### **Arrangements for Handling Heritage Applications Direction 2015**

**PARKWOOD METHODIST CHURCH, PARKWOOD ROAD, LONGWOOD,  
HUDDERSFIELD, WEST YORKSHIRE HD3 4TT**

**Application No. 2020/90480**

Proposed Plans & Elevations

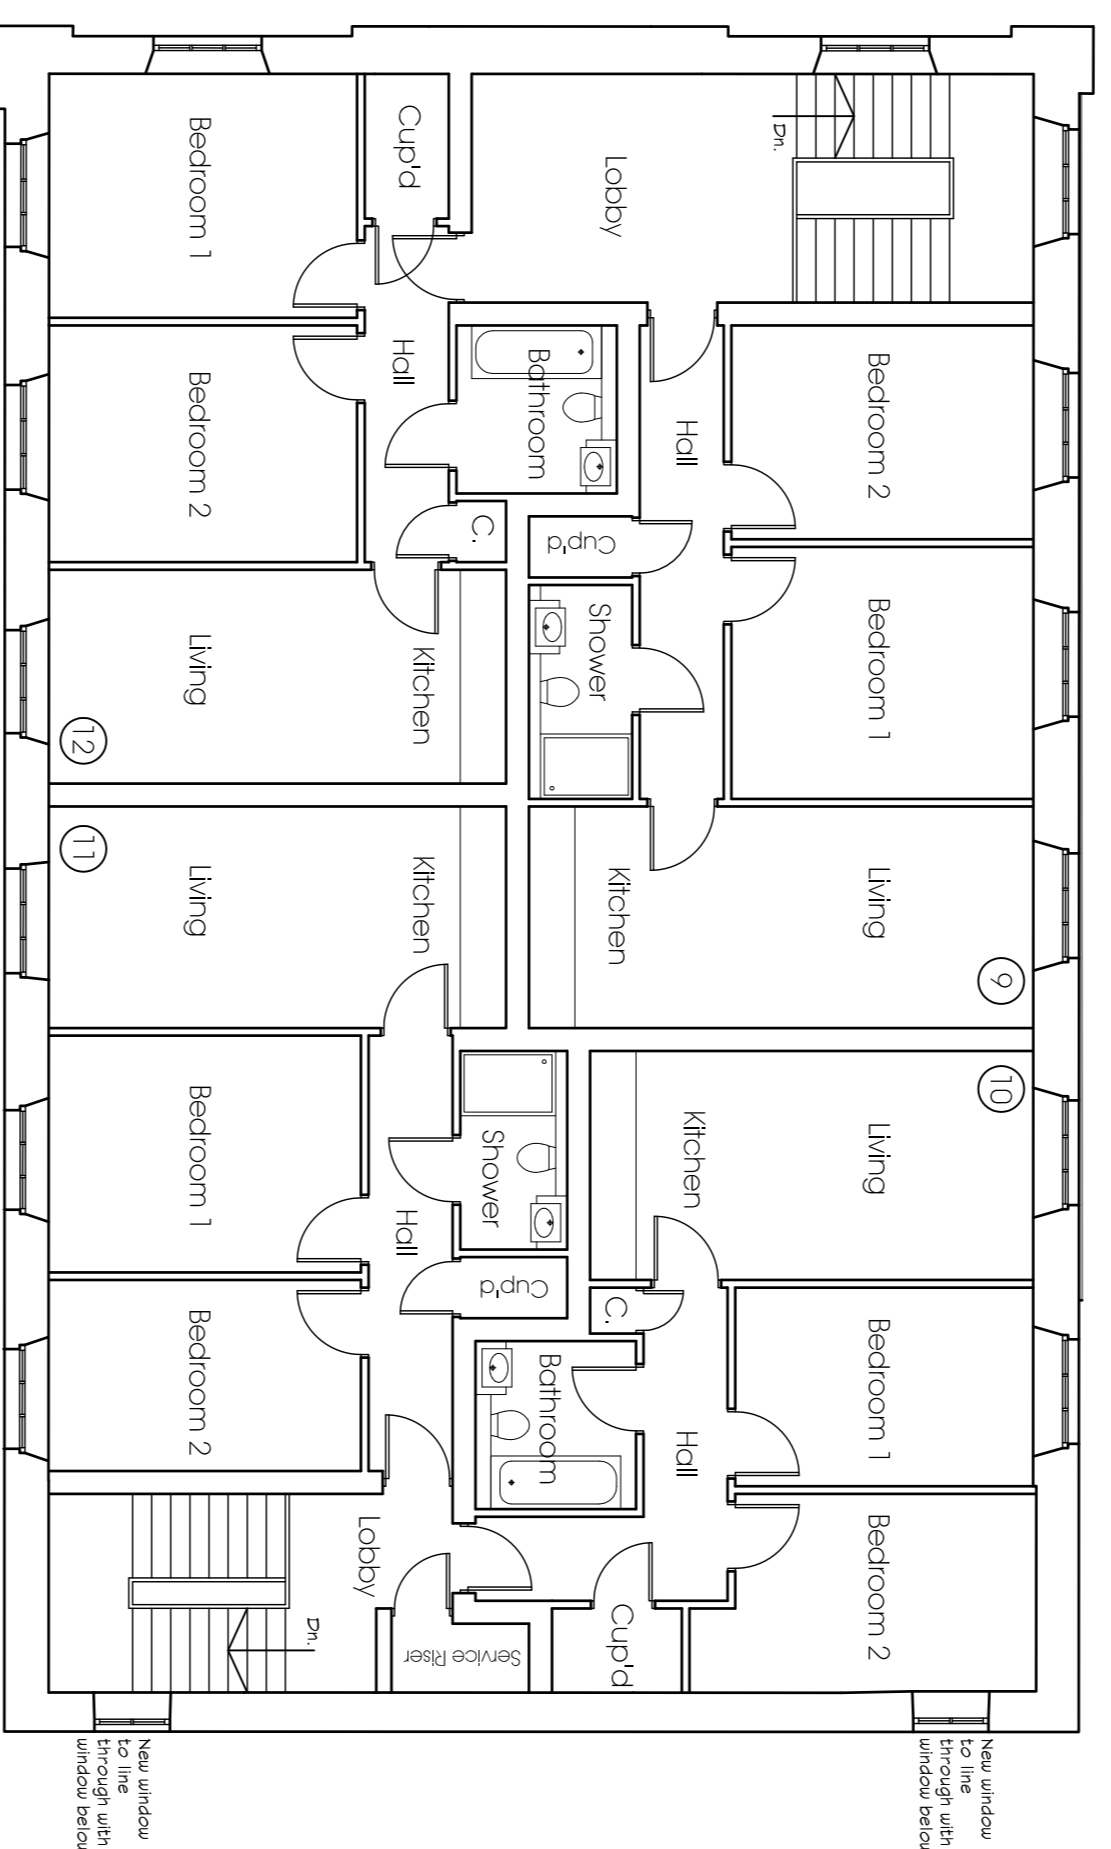
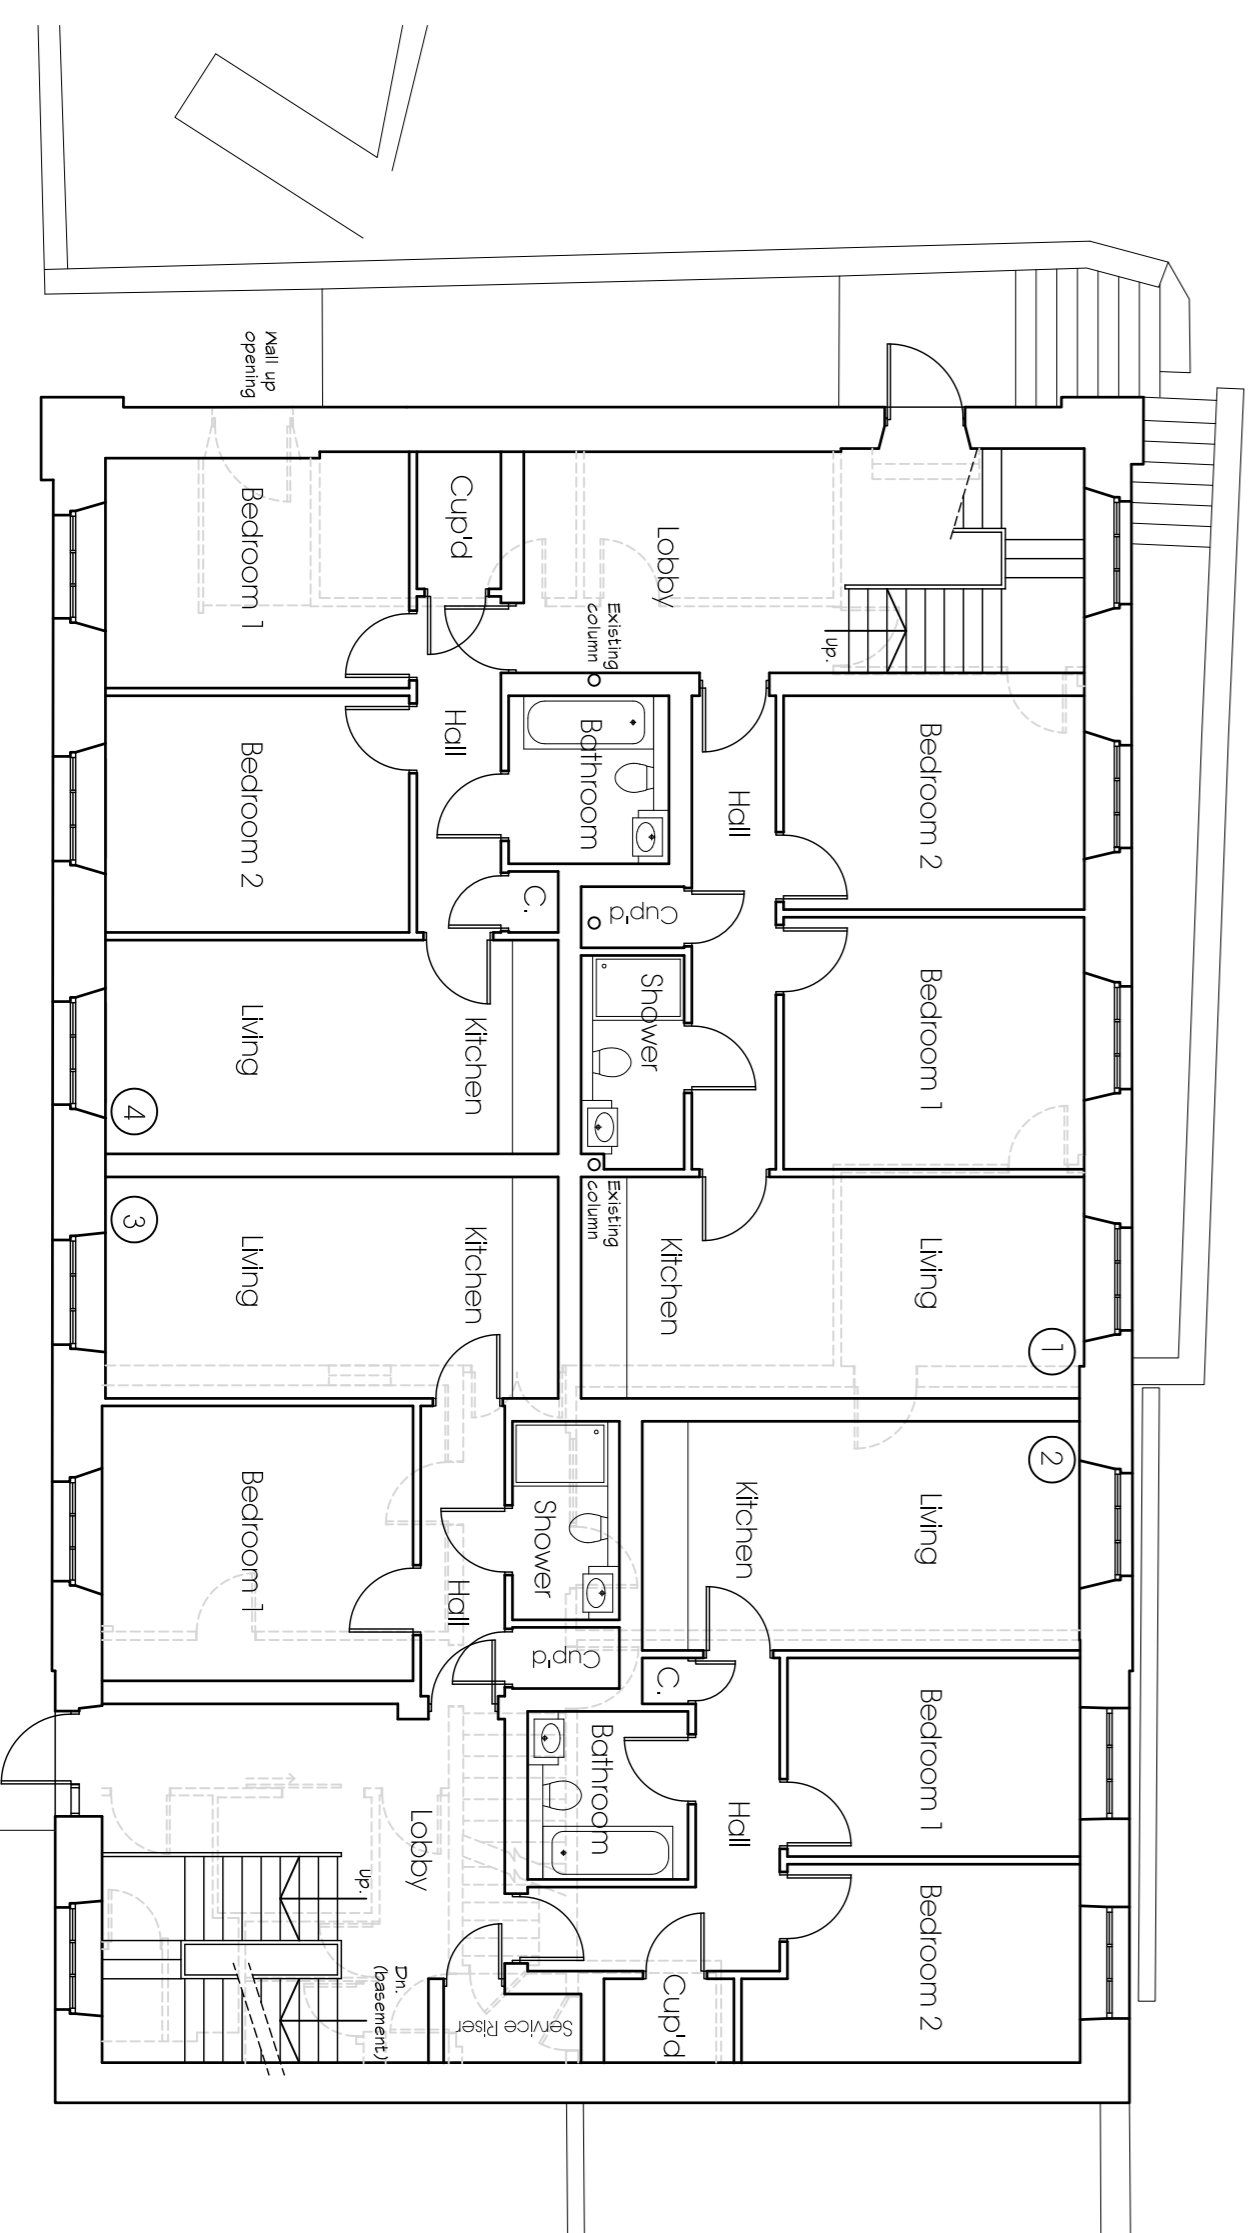
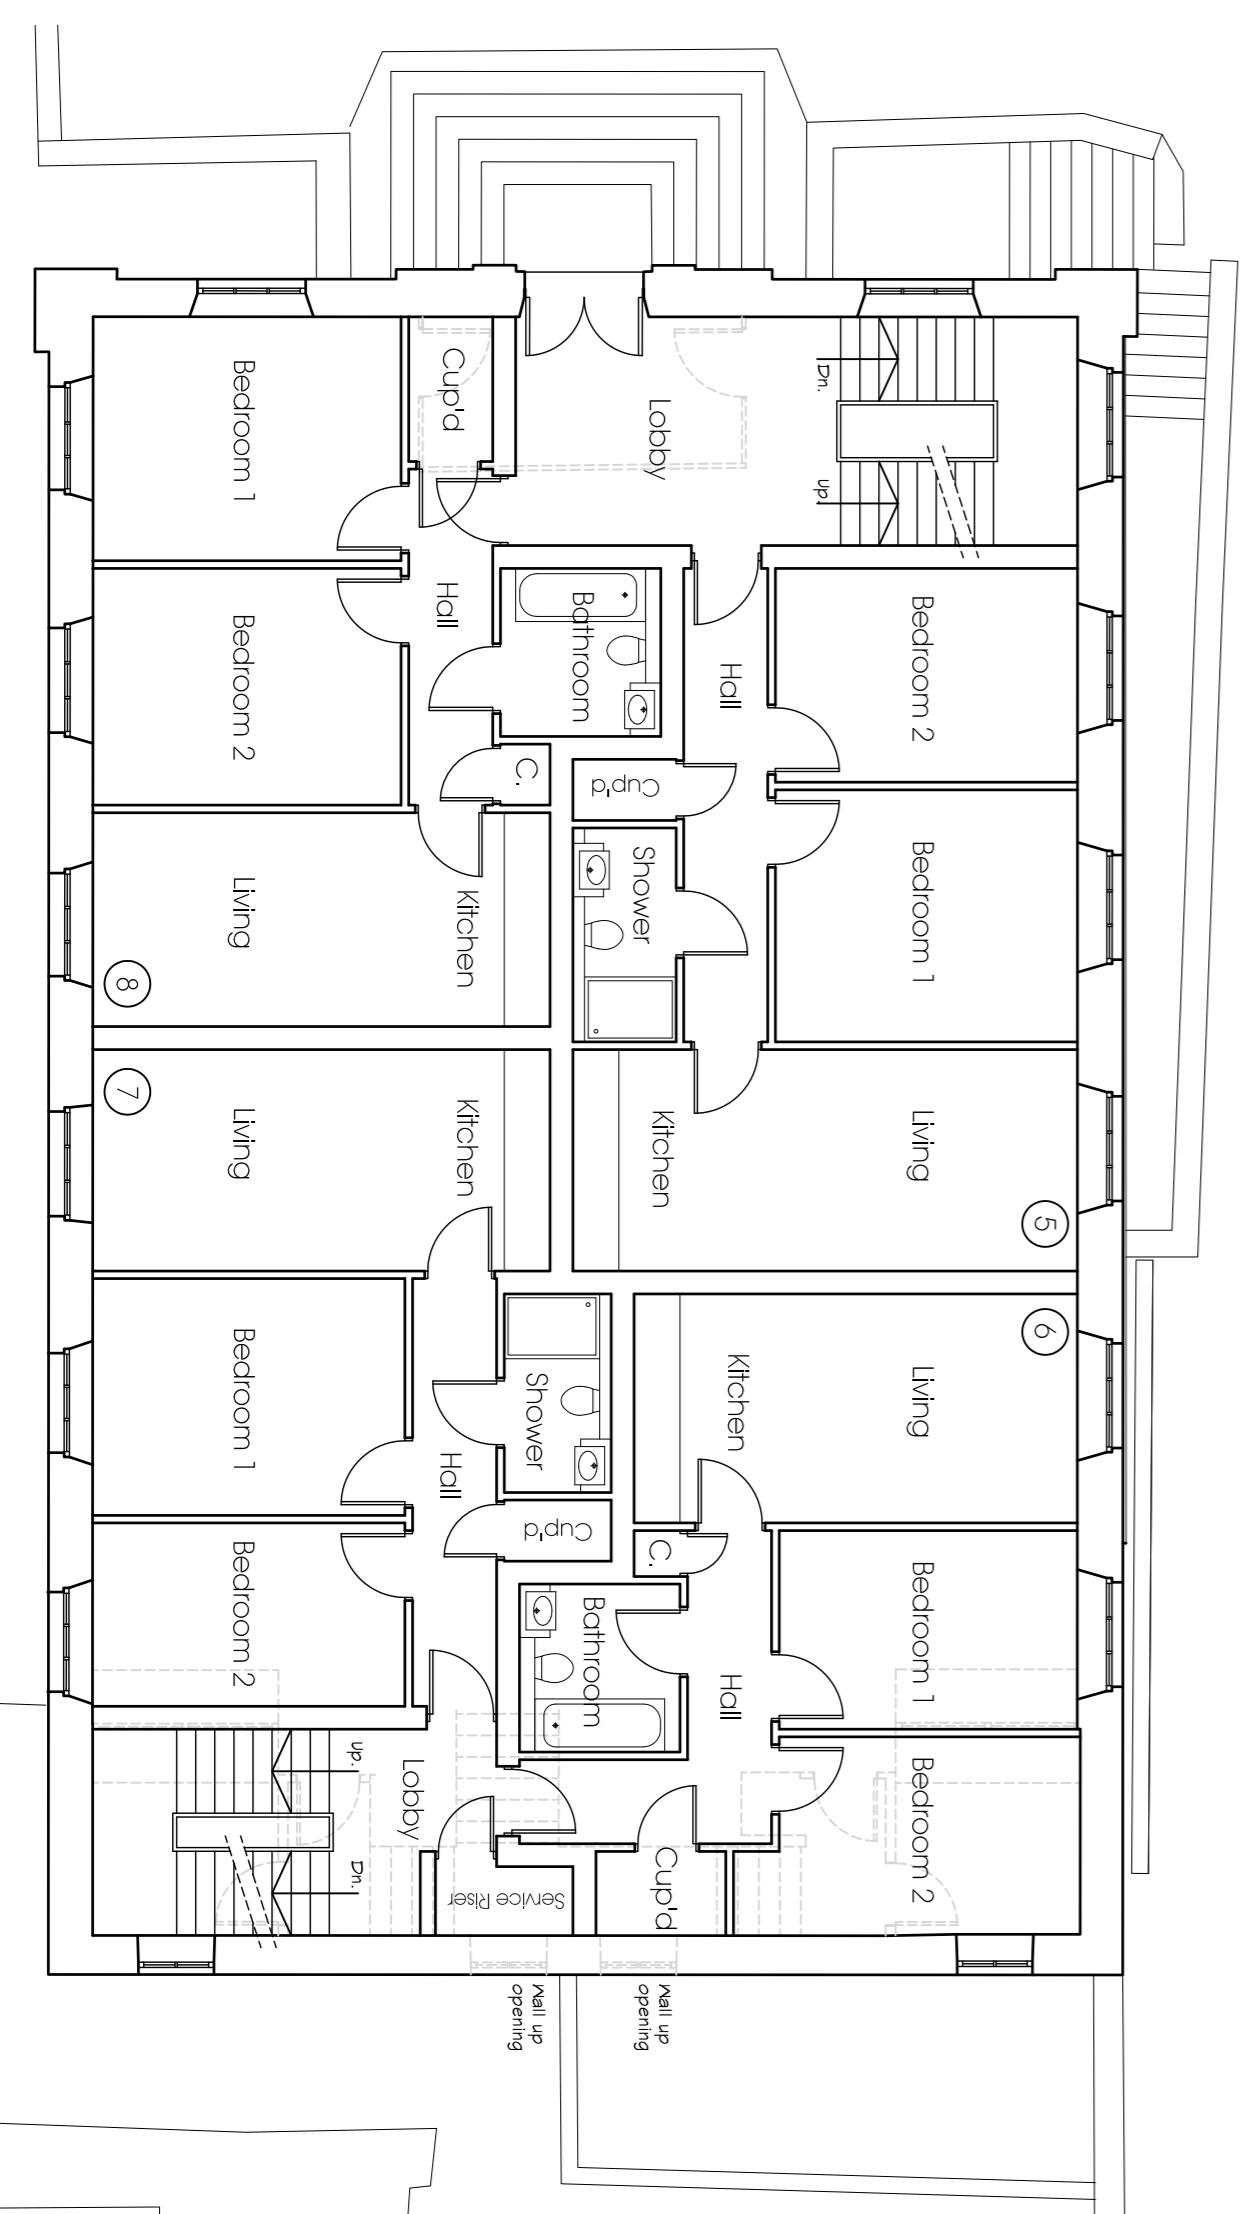
Although we are supportive of the principle of change of use of the building, the harm derived from its conversion to multiple residential uses will have a strong negative impact upon its significance. Relatedly, the parking required to serve these units, particularly the slots located on the east terrace, will be disruptive within the important views of the conservation area in which the church is experienced alongside the mill's buildings, pond and workers houses.

The proposed scheme does not take into account the significance of the building, its architectural detail and qualities of its internal space. The introduction of a standard layout over three floor levels will blur the hierarchies between the more functional – but still strongly symmetrical - lower ground level and main chapel level, being also disruptive on to the double height windows and sense of space of the chapel through its subdivision on two levels. The introduction of two identical staircases at opposite ends throughout the building will alter the sense of hierarchy and progression from the main south entrance to the altar, organ and main pews. Finally, the proposal involves changes to windows and doors which will have a cumulative impact on to our ability to appreciate how the building was originally organized.

Further mitigation can be offered through a more sympathetic design of the internal layout and external arrangements, understanding the role this building plays within important views of the conservation area, and recommend this is pursued and considered. Conversion to residential of places of worship is achievable, and with the right scheme it is possible for the benefits to outweigh the harm.
